WEST SUSSEX COUNTY COUNCIL CONSULTATION

TO:	Arun District Council FAO:Anita Gardner
FROM:	WSCC - Highways Authority
DATE:	14 April 2020
LOCATION:	Broomhurst Farm Lyminster Road Littlehampton BN17 7QW
SUBJECT:	LY/4/20/PL Erection of steel framed storage barn.
DATE OF SITE VISIT:	n/a
RECOMMENDATION:	Modification
S106 CONTRIBUTION TOTAL:	n/a

Proposed Barn Plans and Elevations

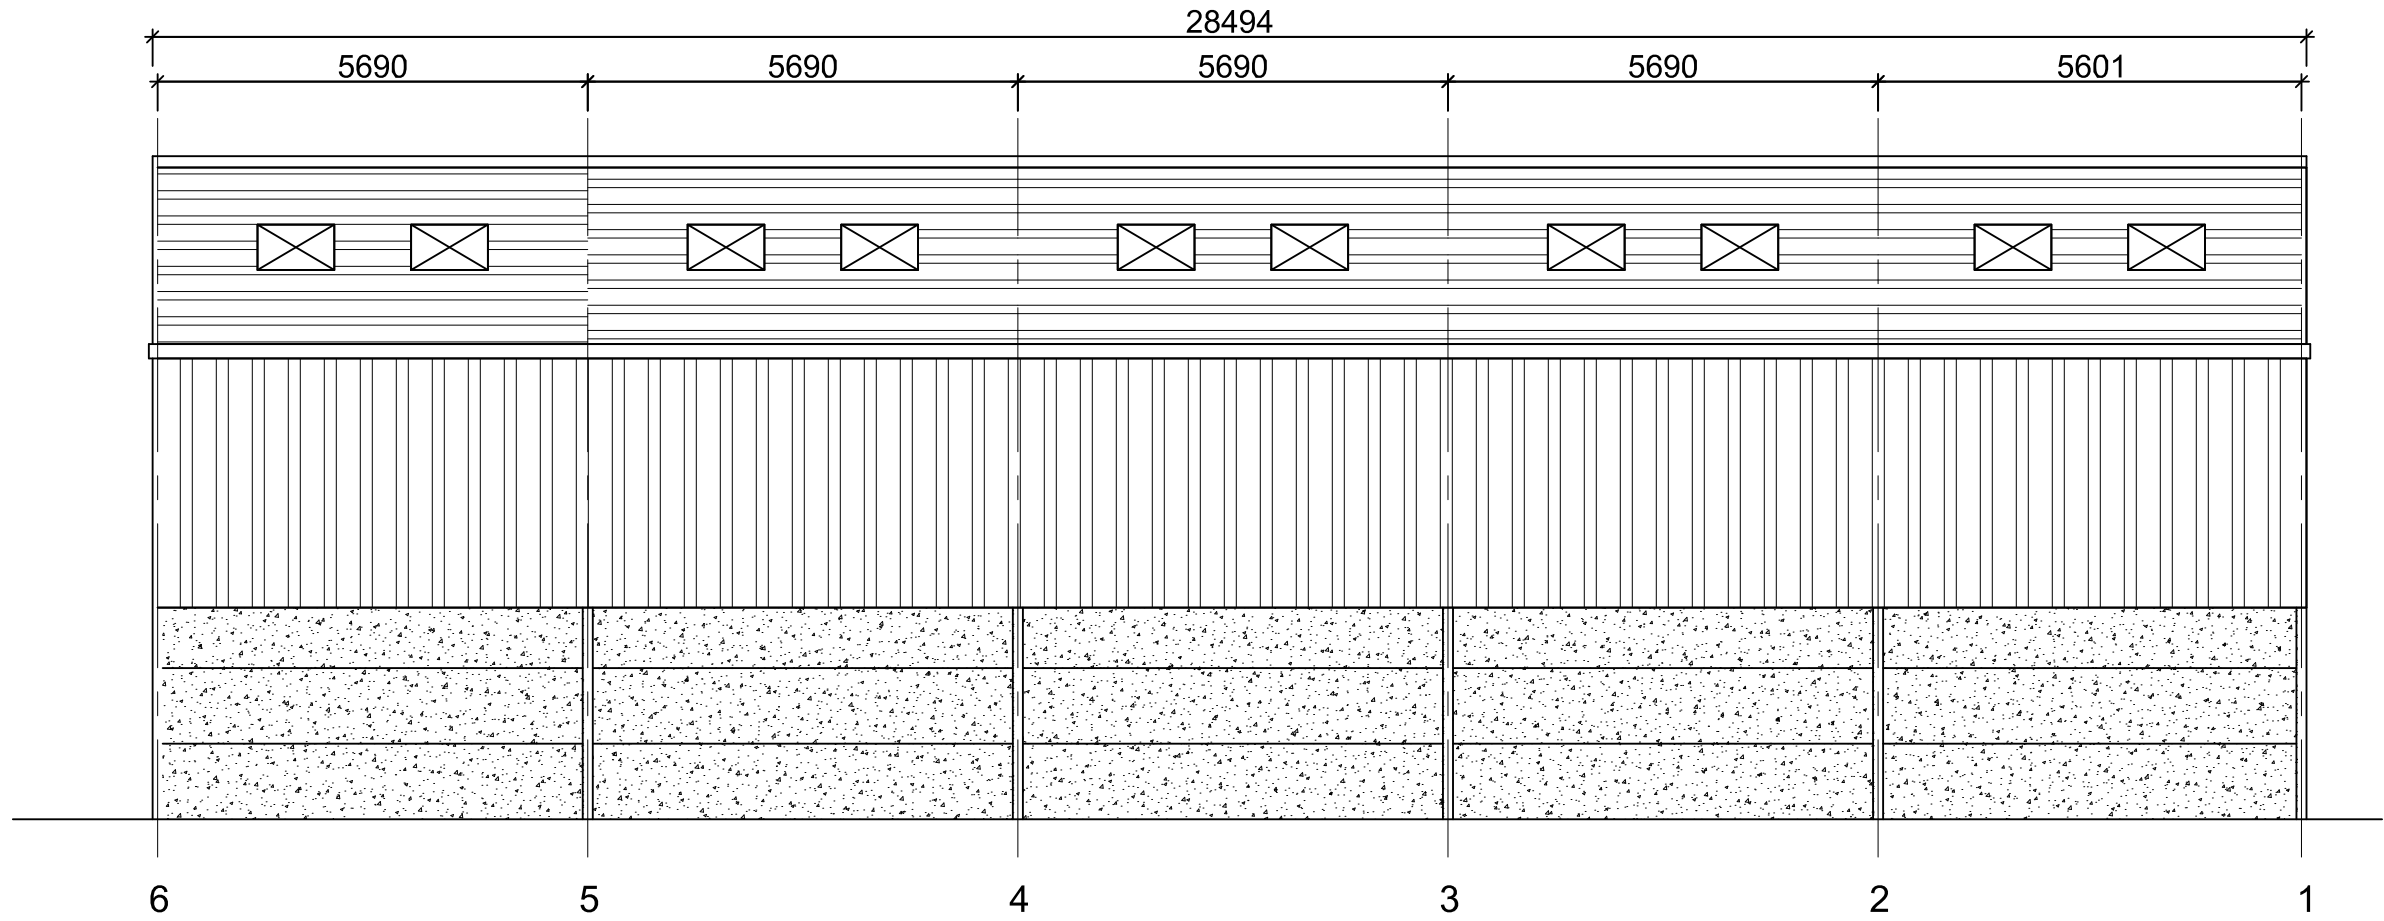
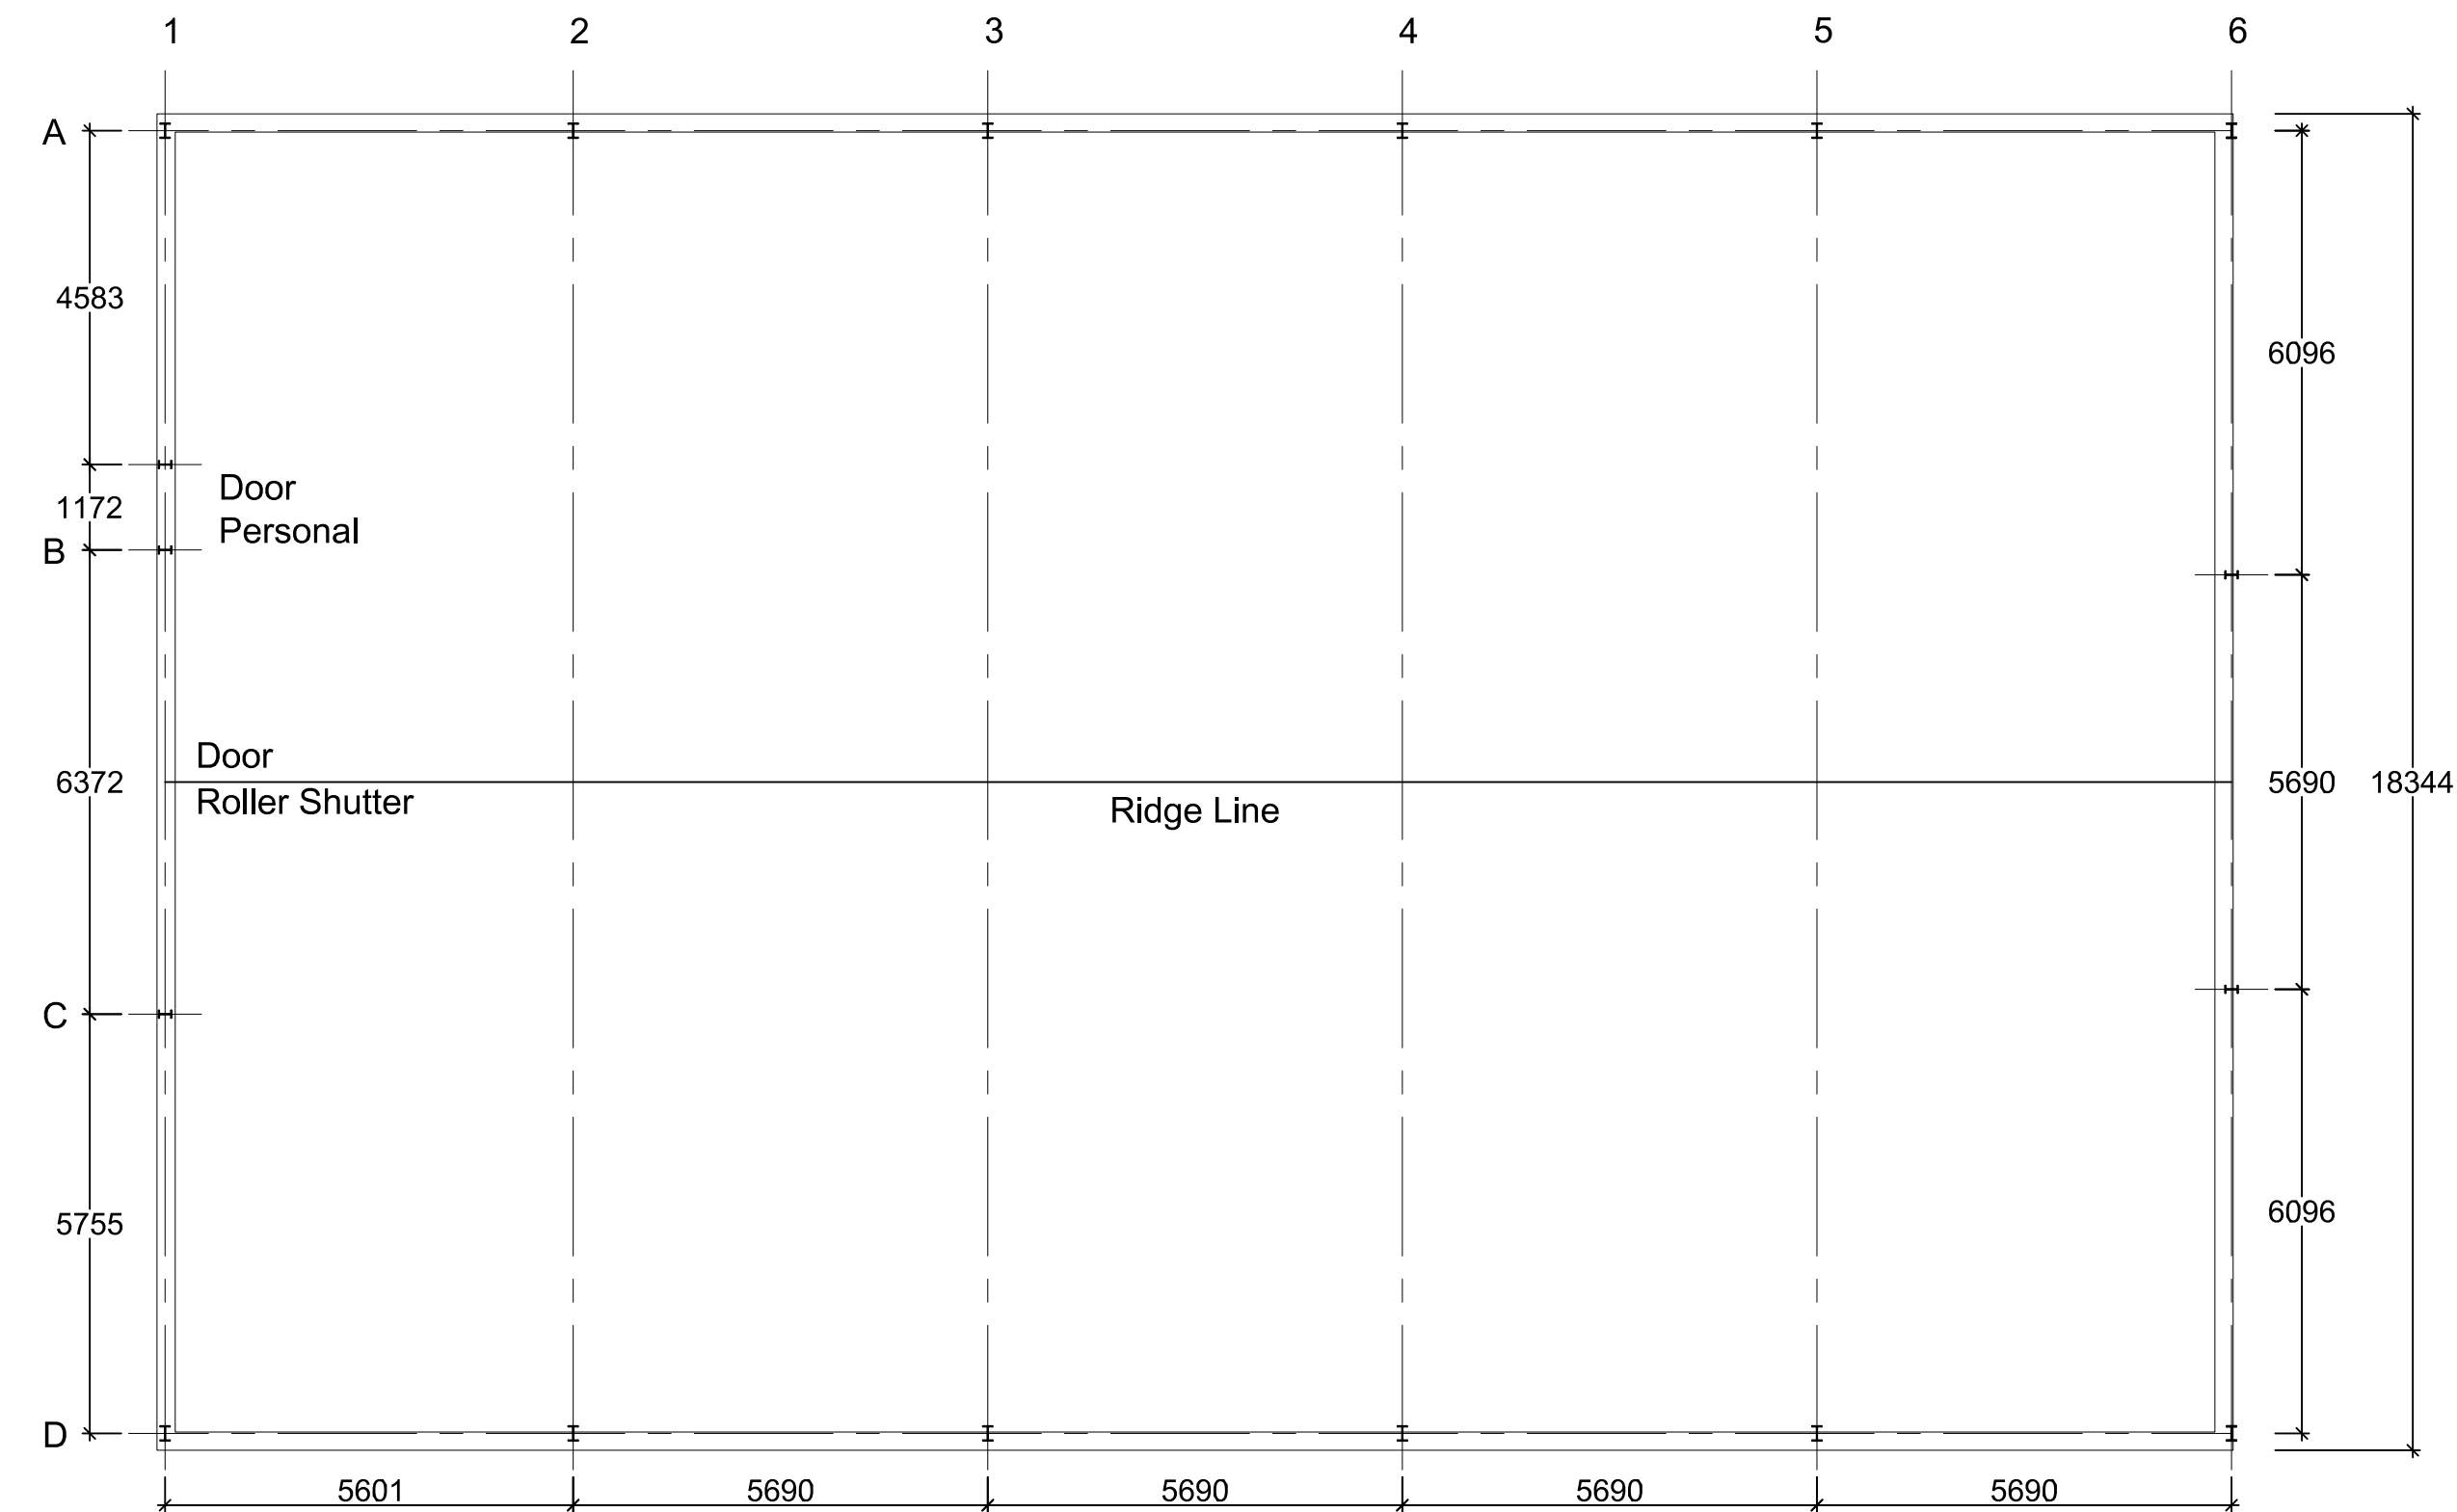
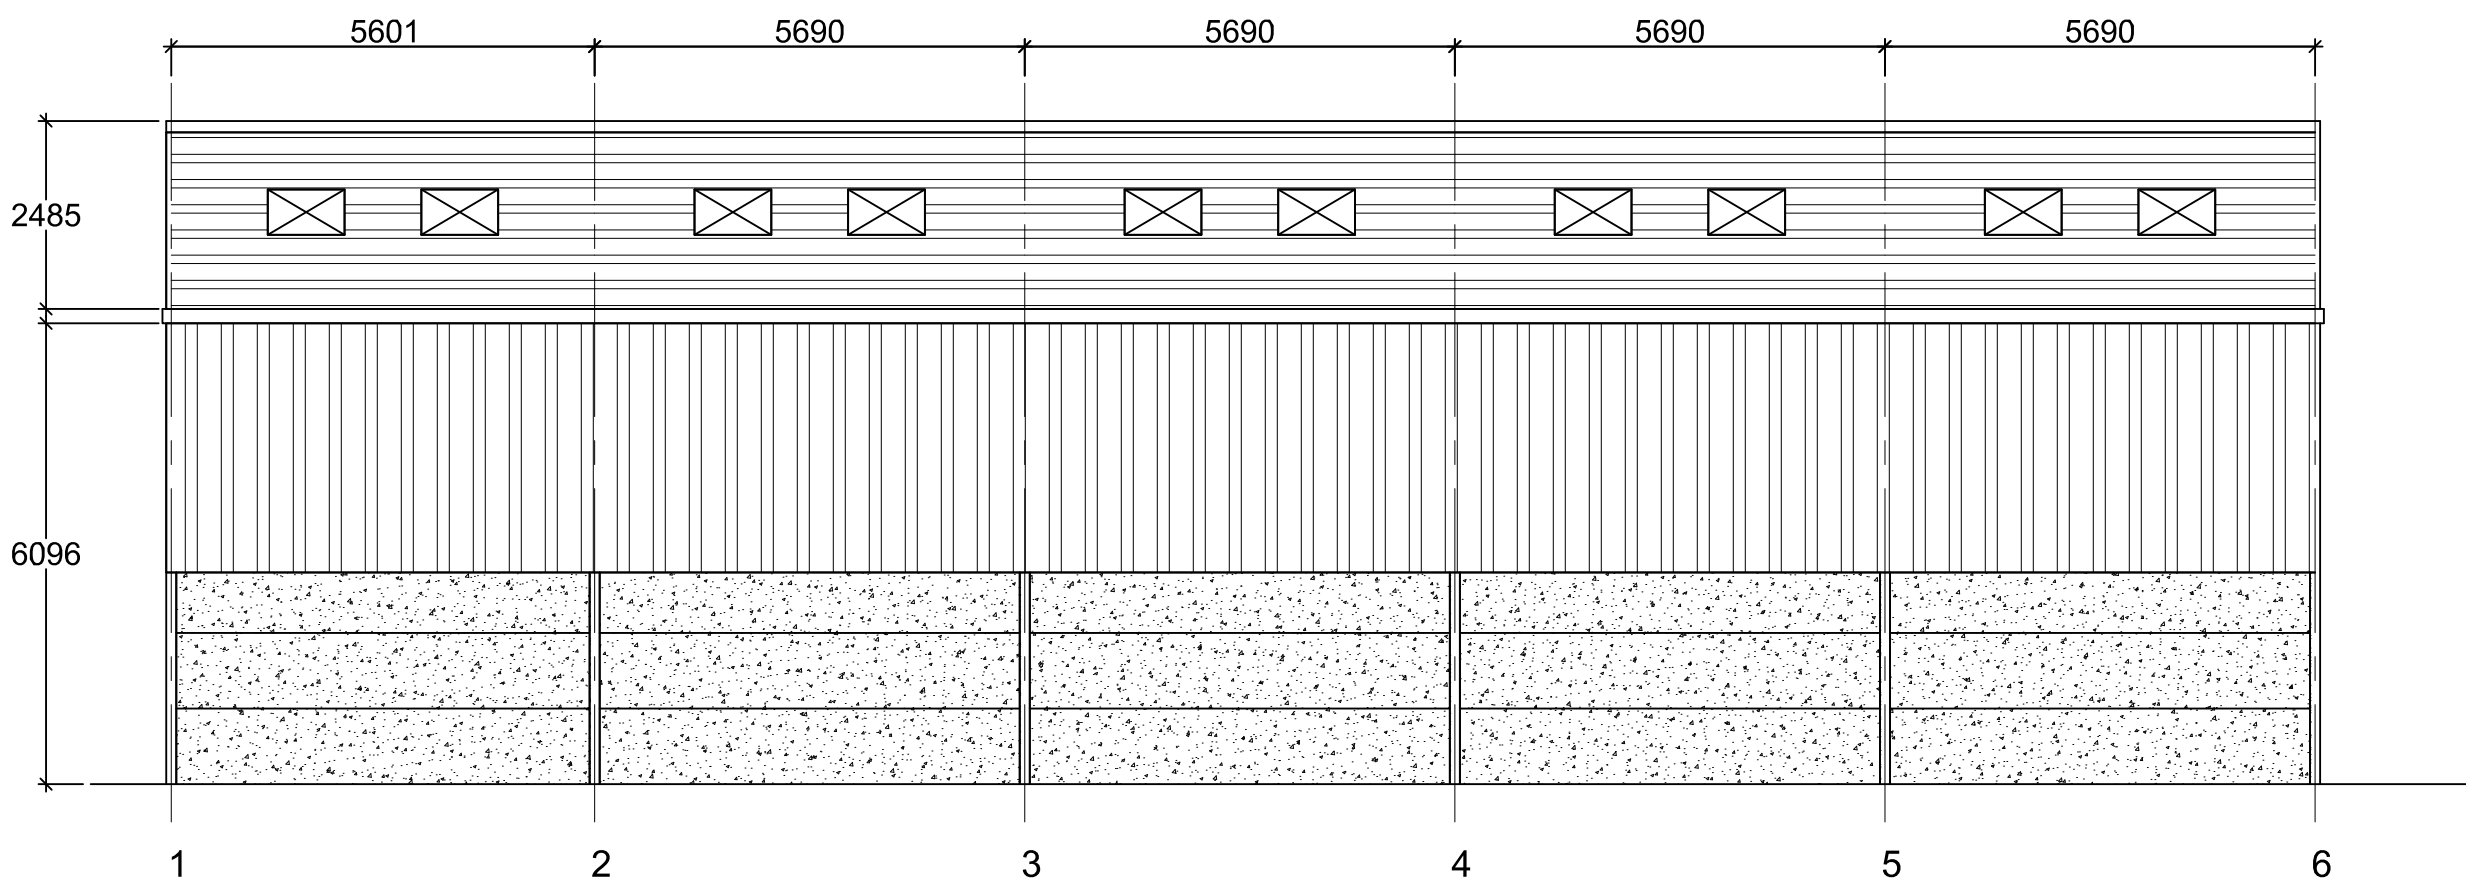
The applicant proposes a NIL car parking provision for the new B8 use.

However, the LHA notes that the hardstanding on the frontage of the barn measuring 18 x 12 metres would be large enough to accommodate nine parking spaces. The LHA wishes the applicant modifies the plans to show that the anticipated five parking spaces can be accommodate within this hardstanding area.

In principle the Local Highways Authority (LHA) does not consider that this proposal would have an unacceptable impact on highway safety or result in 'severe' cumulative impacts on the operation of the highway network. However, the LHA require a modification regarding the Car Parking, as described above.
